A1 in Northumberland: Morpeth to Ellingham

Scheme Number: TR010059

Summary of Proposed Changes to Application

December 2020

Indicative Earthwork Change Locations

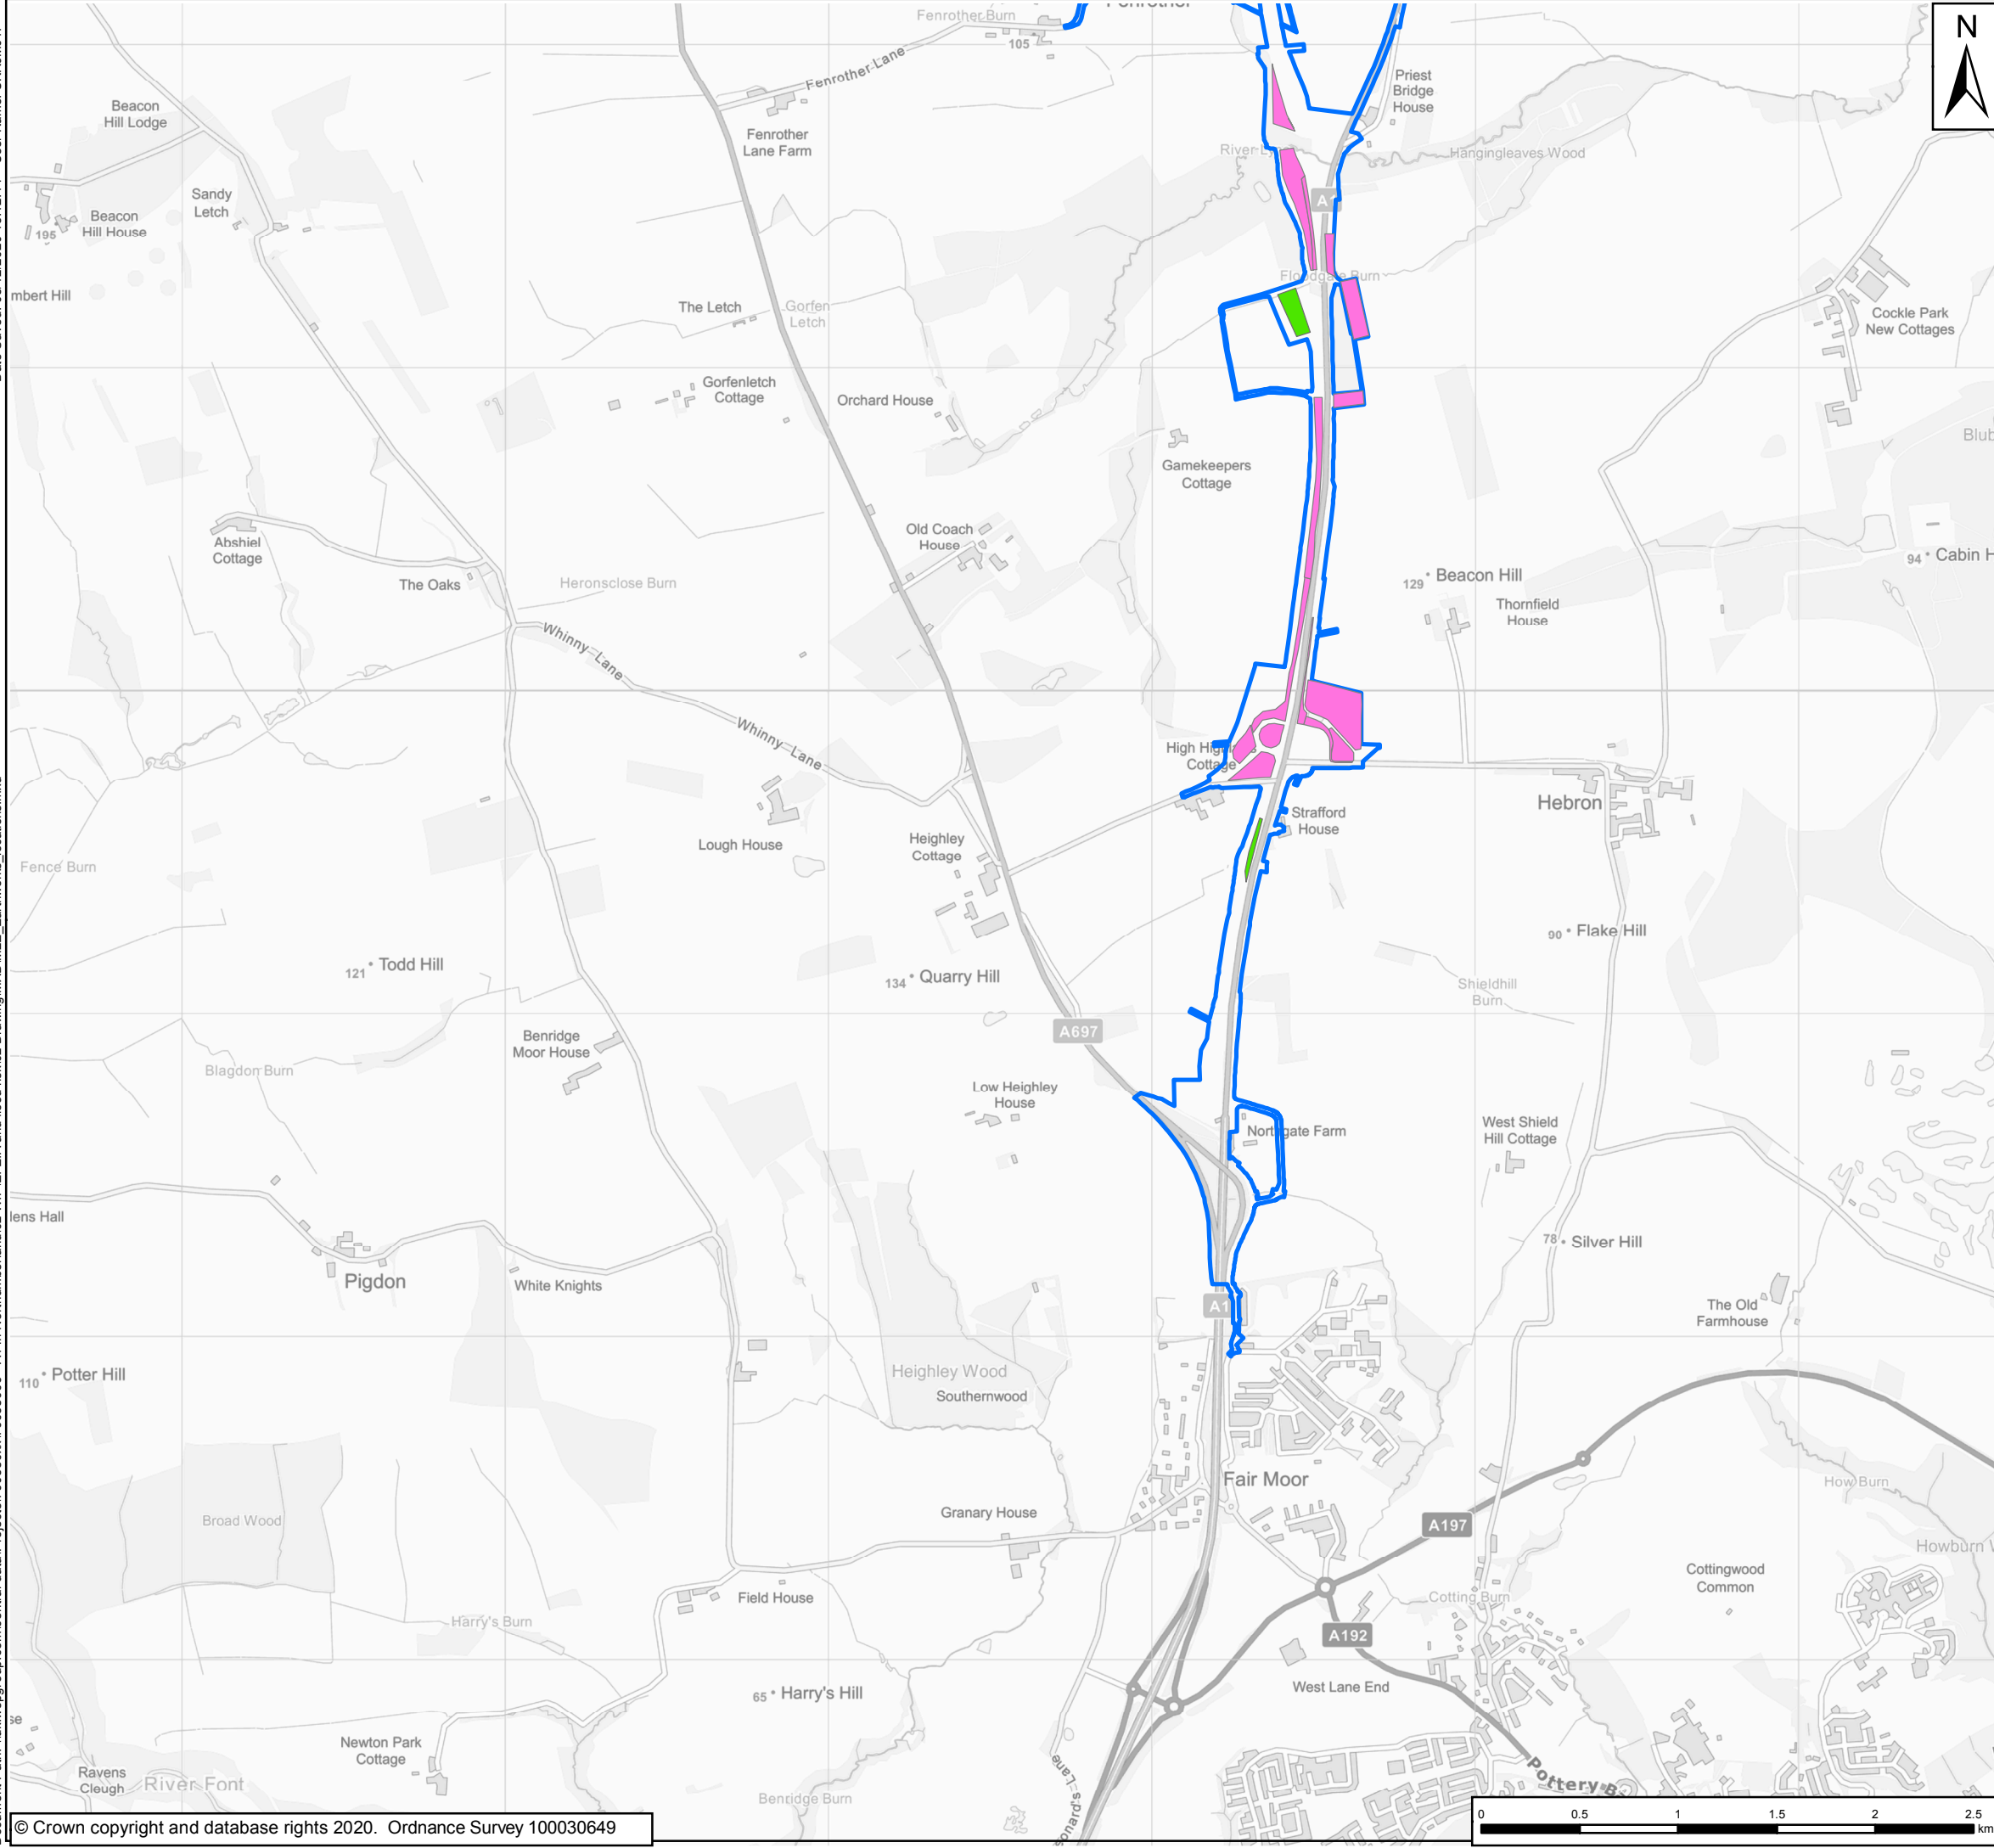
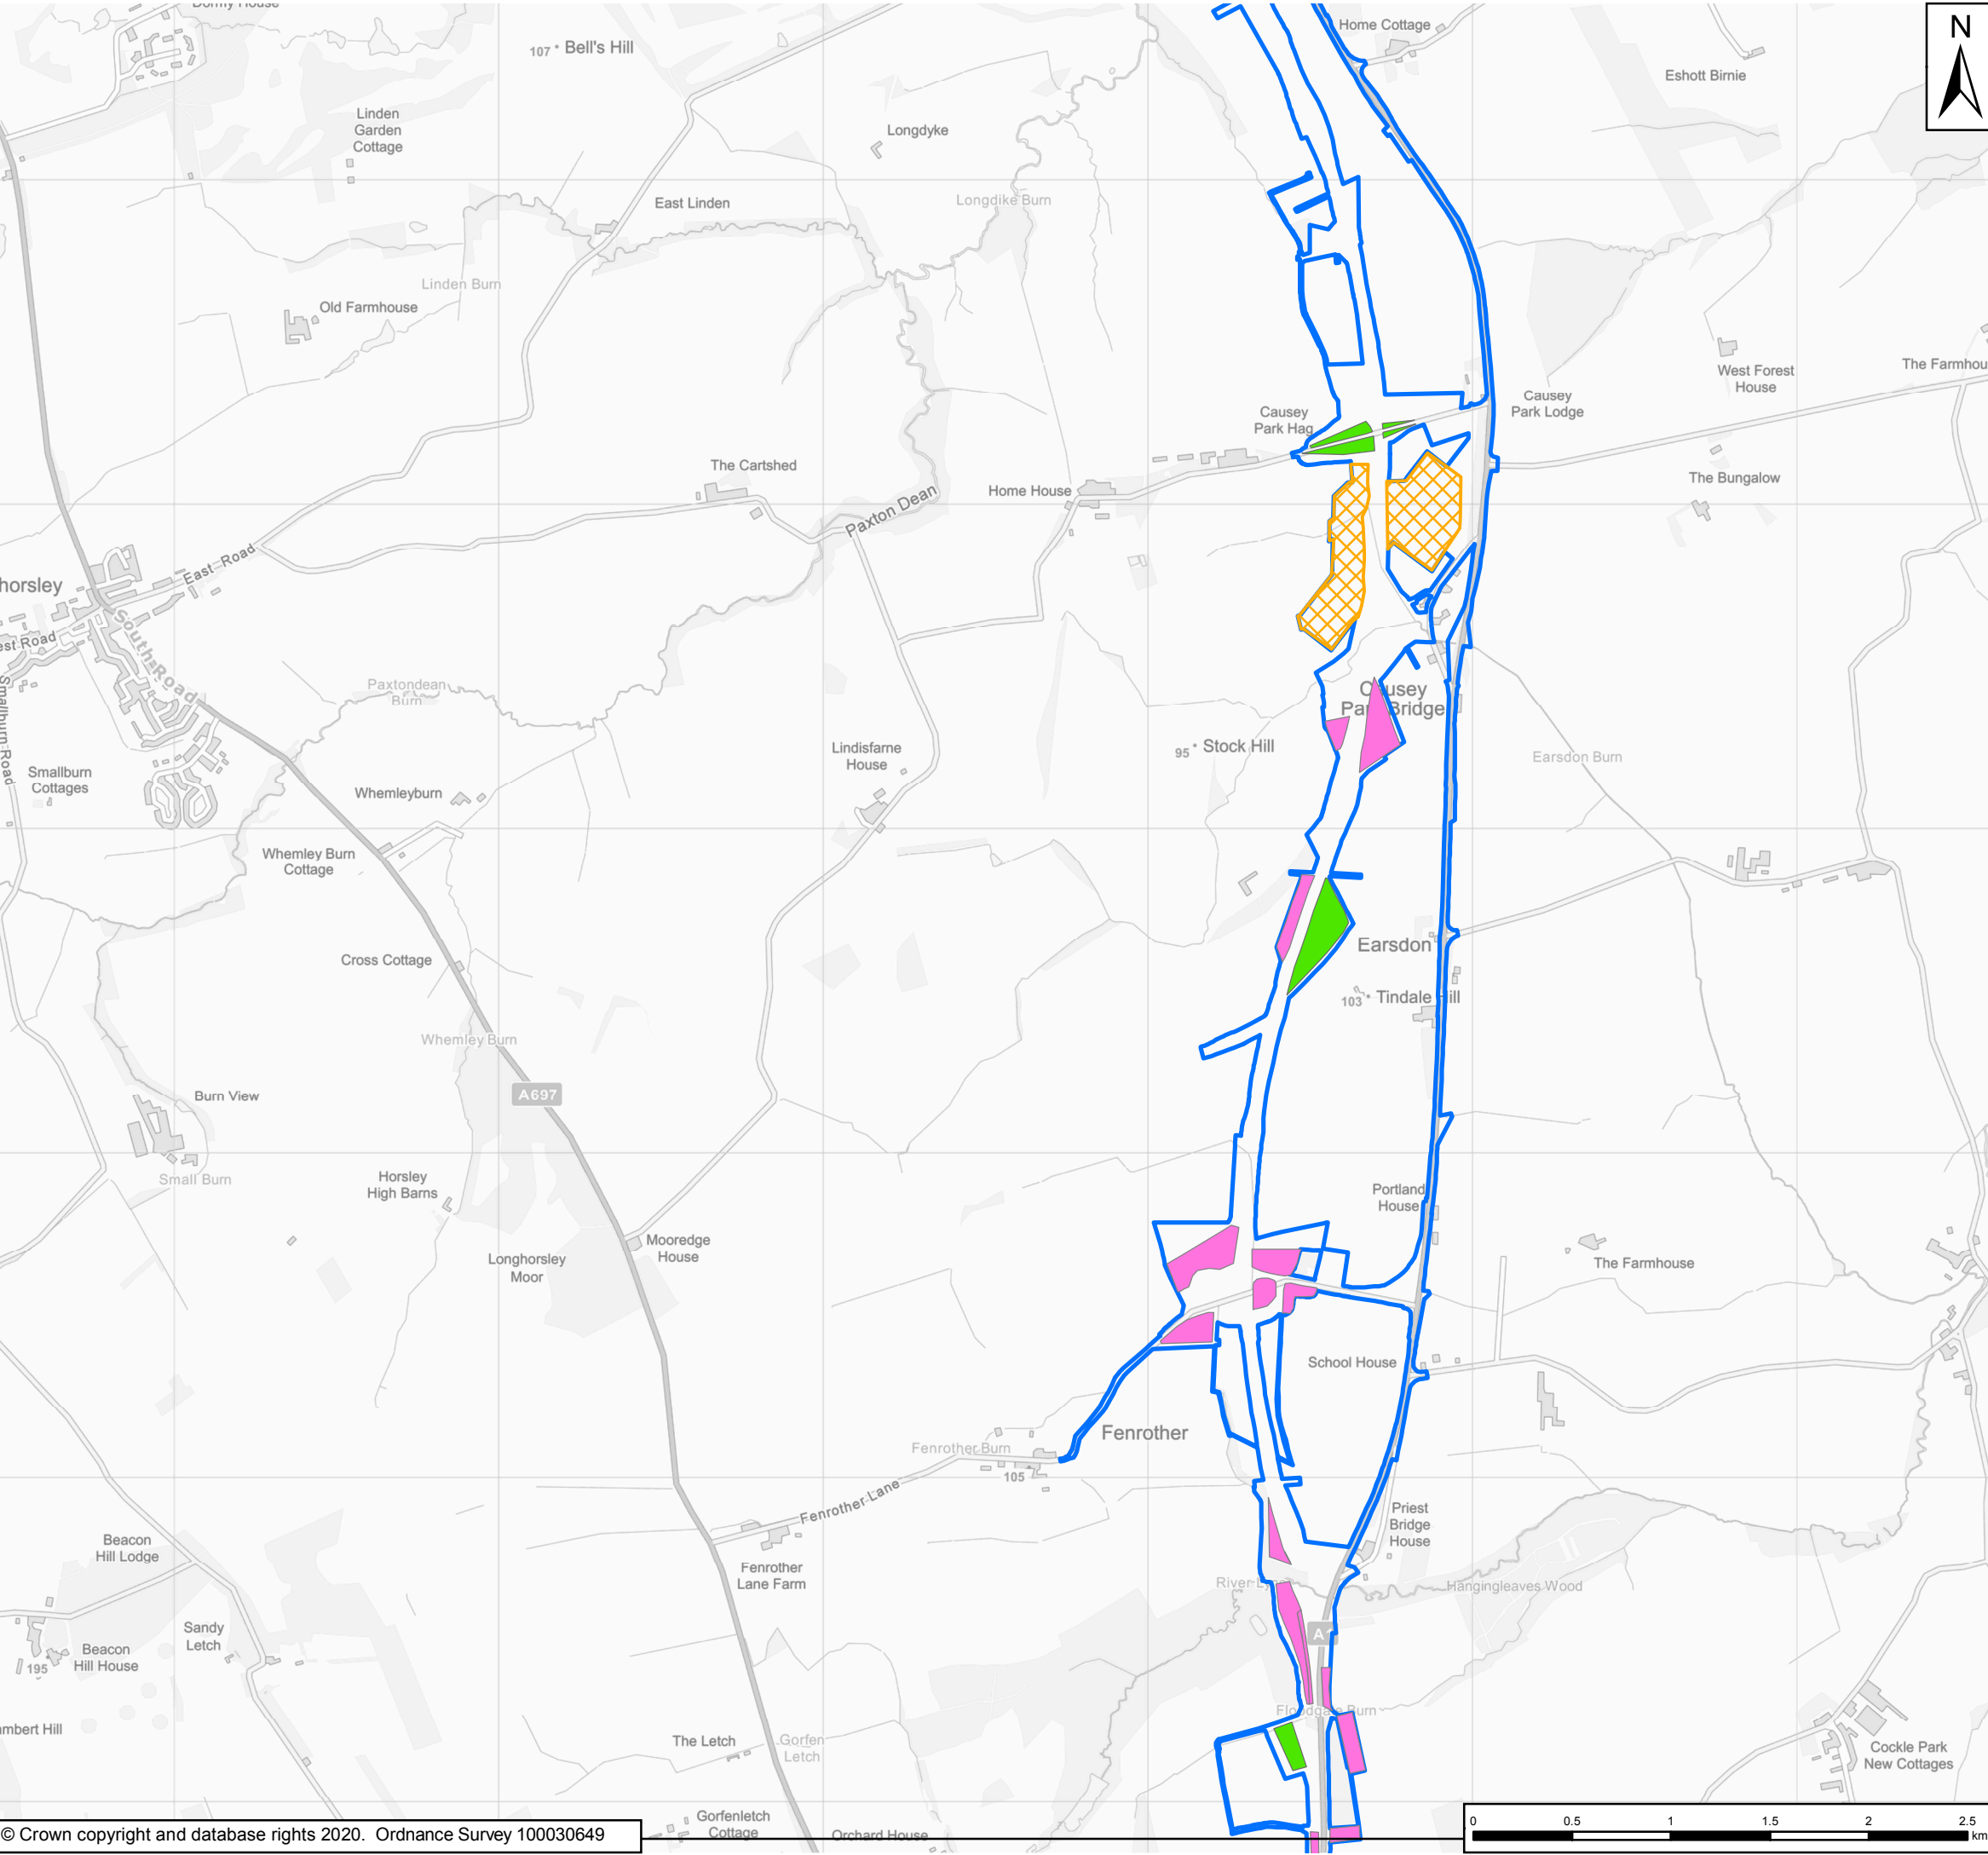
- 2.1.1 The Applicant proposes to maximise the re-use of materials (via excavation, deposition and temporary storage), within the existing Scheme extents. A recent review of the earthworks strategy has identified an opportunity to reduce earthwork movement and as a result greater flexibility in temporary and permanent storage of Site won material is required to achieve this. The indicative earthworks areas are shown in the figure in the **Indicative Earthwork Change Locations** figure in **Appendix A**.

- 2.1.2 To balance materials across both Parts A and B, the following methods are proposed:
- Utilising borrow pits to exchange and win additional material suitable for construction.

- Creation of new soil bunds within Part B to maximise re-use of excess site material.
 - Maximising of slopes for re-use of excess site material, in Part B.

- Laying down additional material increasing some localised ground levels.
 - Raising levels of junction “bowls” (level or rounded rather than dished).

- Creating new, temporary soil storage areas within both Part A and Part B.
- 2.1.3 These changes are an alteration to Parameters 4 and 5 for Part A, as set out in **Chapter 2: The Scheme** of the ES [APP-037]. There would also be additional temporary and permanent earthworks that require assessment for Part A and Part B. Therefore, it is appropriate to ensure that the environmental information before the Examination addresses the prospect of altered impacts This is addressed by sensitivity testing as described at **paragraph 2.1.6** below.
